**Subject:** FW: Notification of Invalidity Letter for Application No 23/1203/DTC

Further to receiving the attached invalid letter for Condition 5 (War Memorial), please find attached the updated drawing, covering letter and comments below:

FT6 - Coat of Arms indicative detail - NBS Q50 340 - For condition submission
1:20

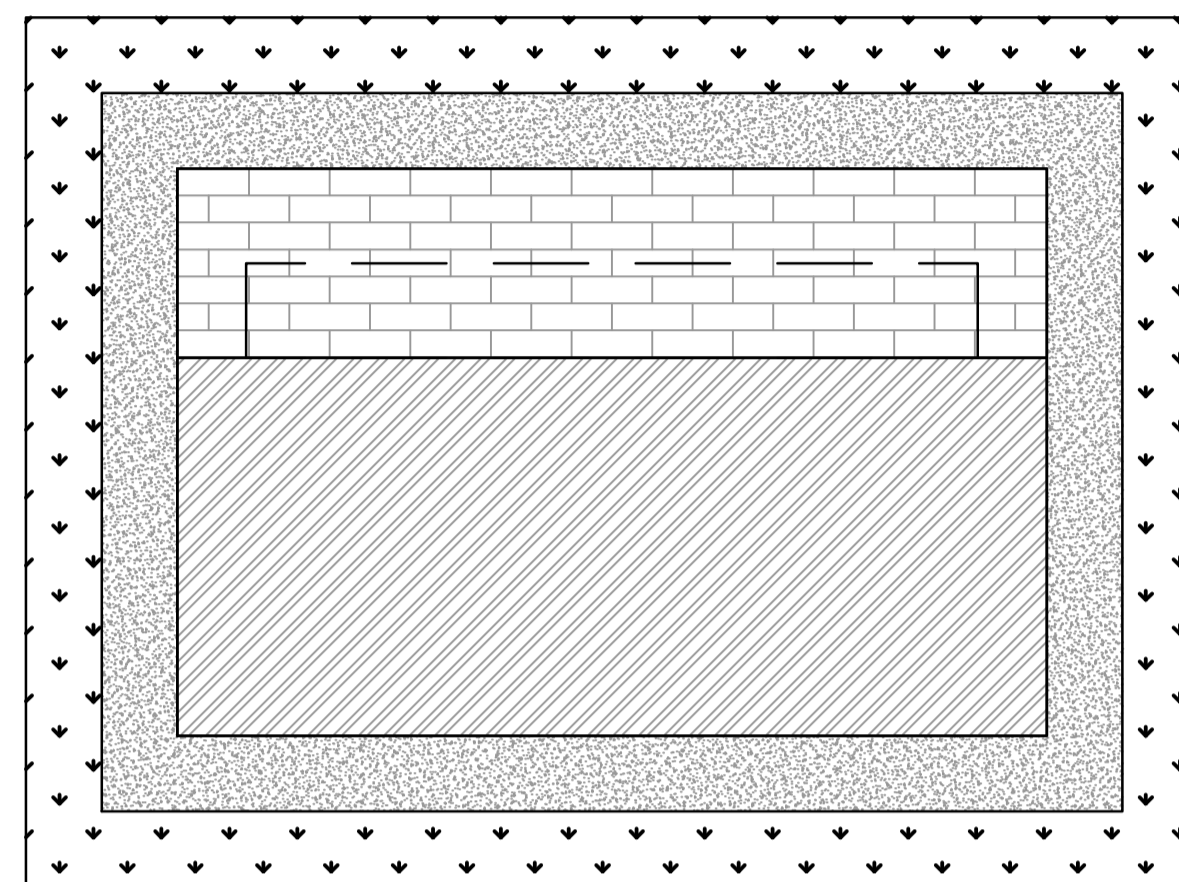
- please provide a method statement for the relocation, redesign and rebuilding of the memorial. **Detail can be provided in due course however please see key points below:**

2. **Consultants will finalise the design for the supporting foundation and brickwork surrounds**
    3. **Works will commenced onsite by constructing the foundation indicated on drawing 5020.**

Overview plan of FT6 - Coat of Arms
1:100

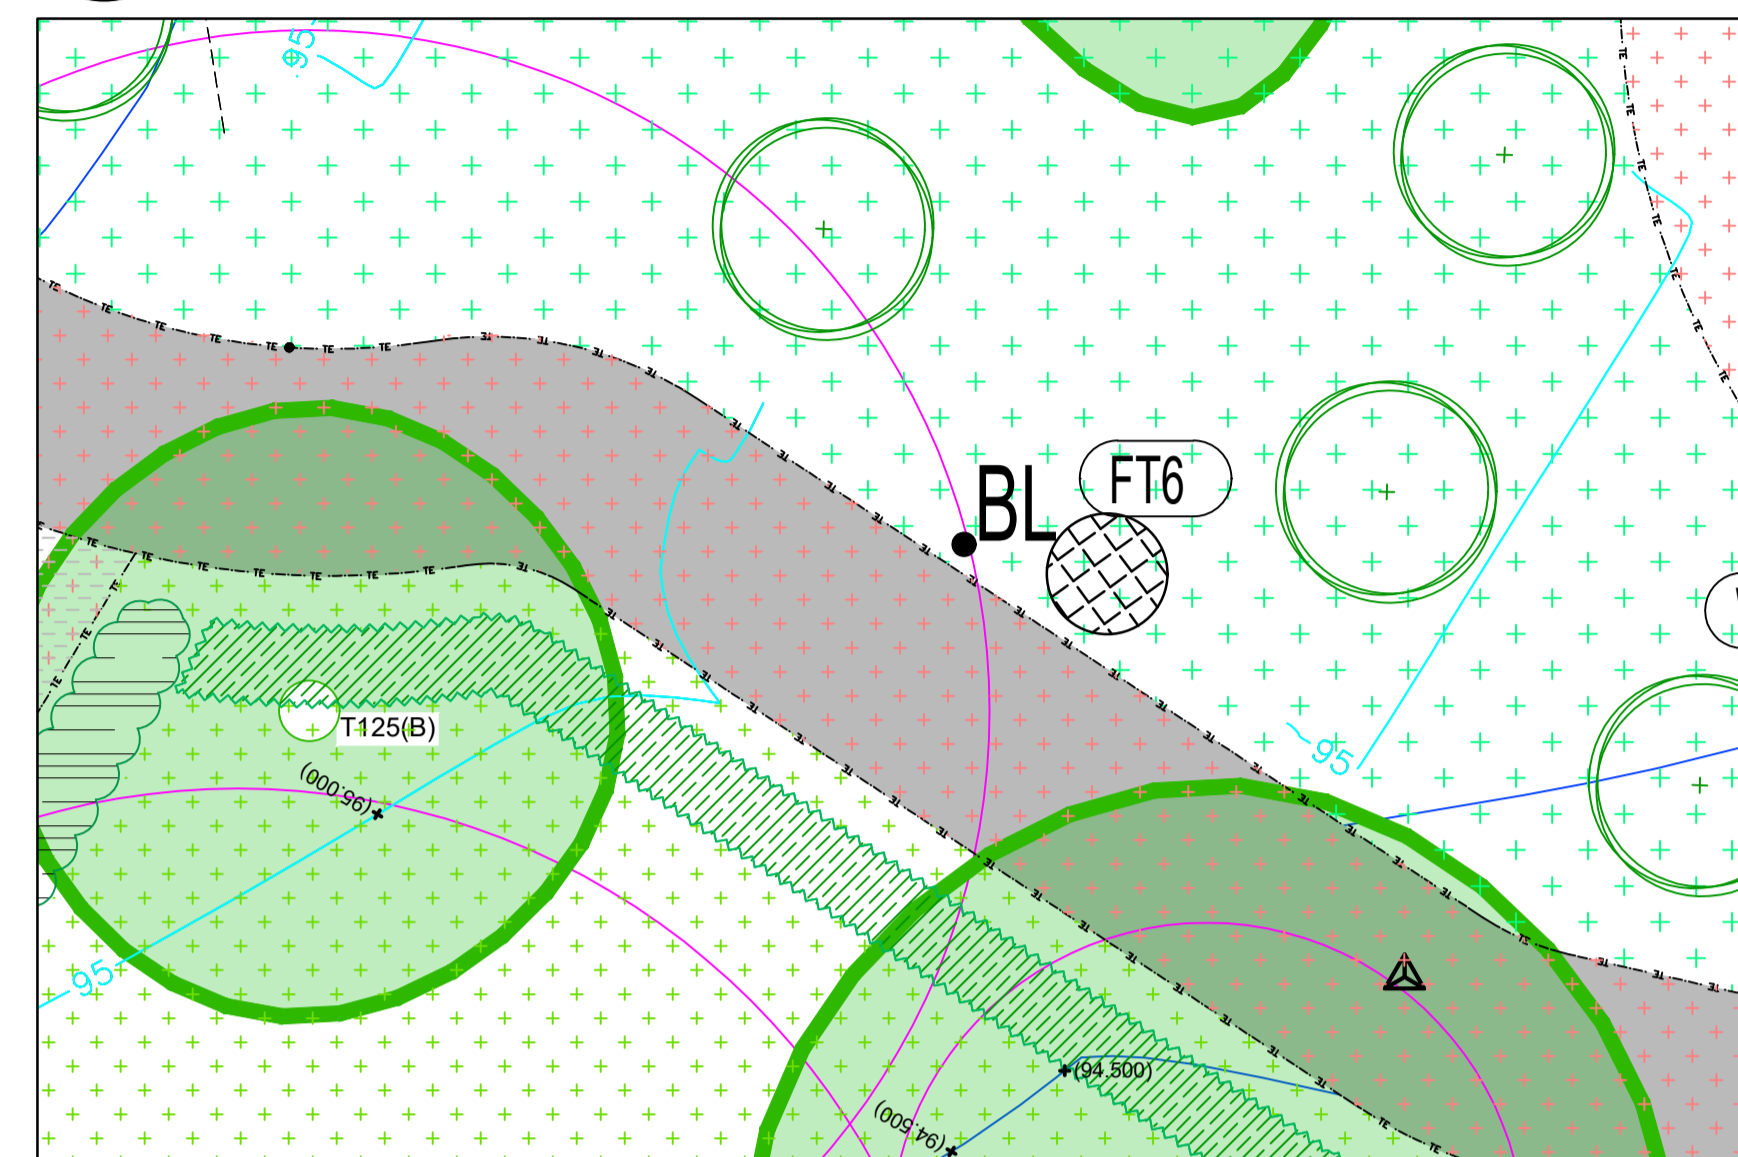
2. Although not invalid for the following reason, the information below will be requested to enable the full consideration of the application.
  - please provide a detailed site layout for the location of the war memorial to include existing and proposed level information and whether a plinth will be required; **The memorial is located where the existing church hall is within the formal park. Proposed level to match the footpath running E-W. A nominal 100mm plinth or similar will be provided**

REAR ELEVATION

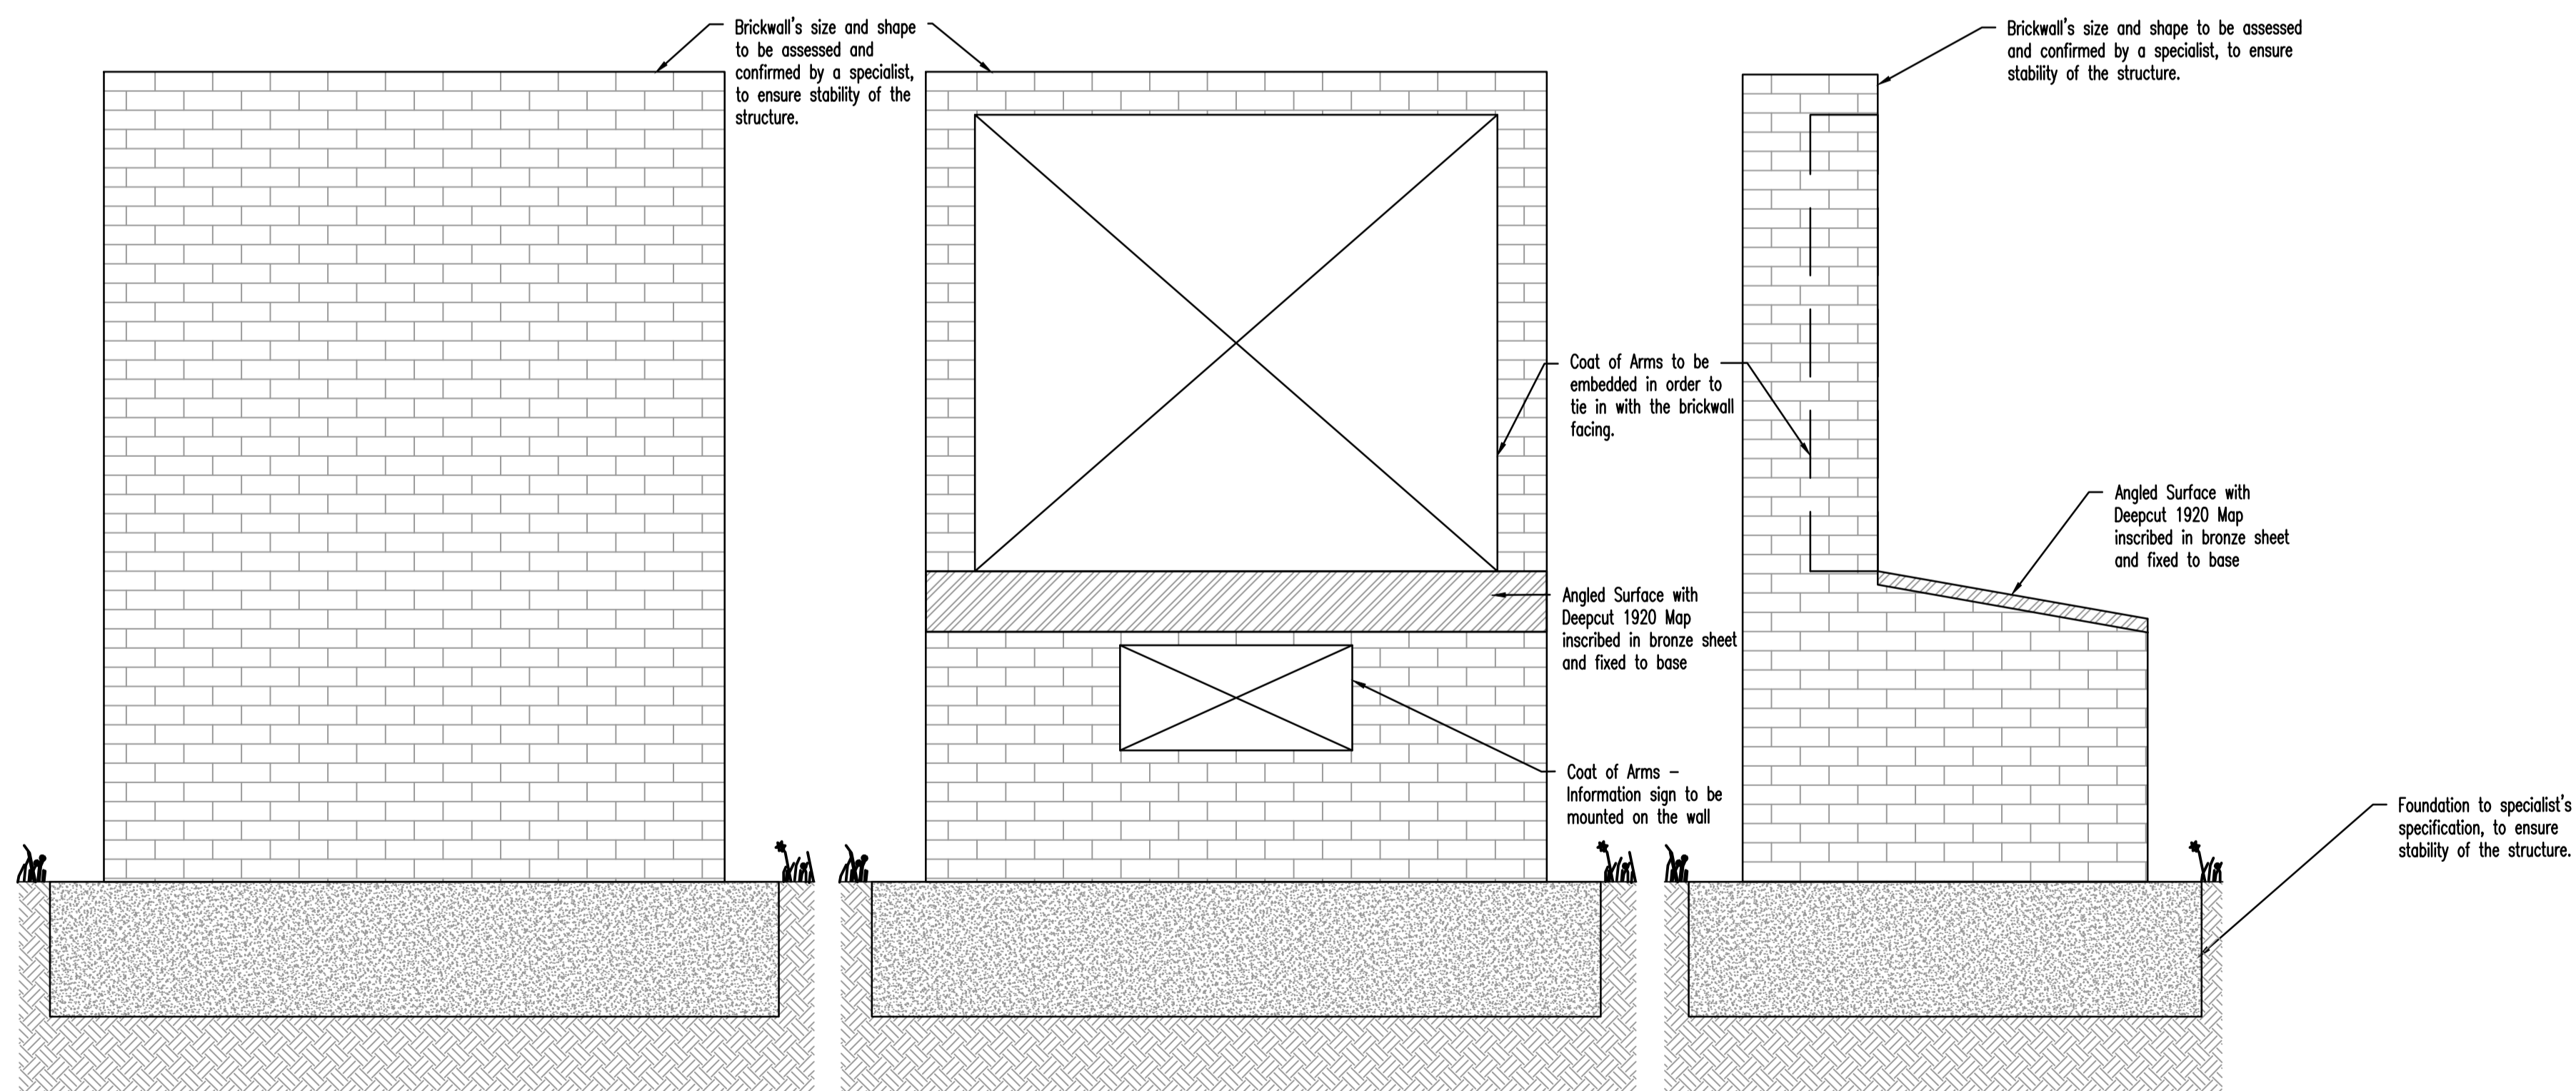
1. Please provide details of the rear elevation and confirm the other side elevation is the same as the one provided, albeit handed.- **please refer to updated drawing 5020 C02.**
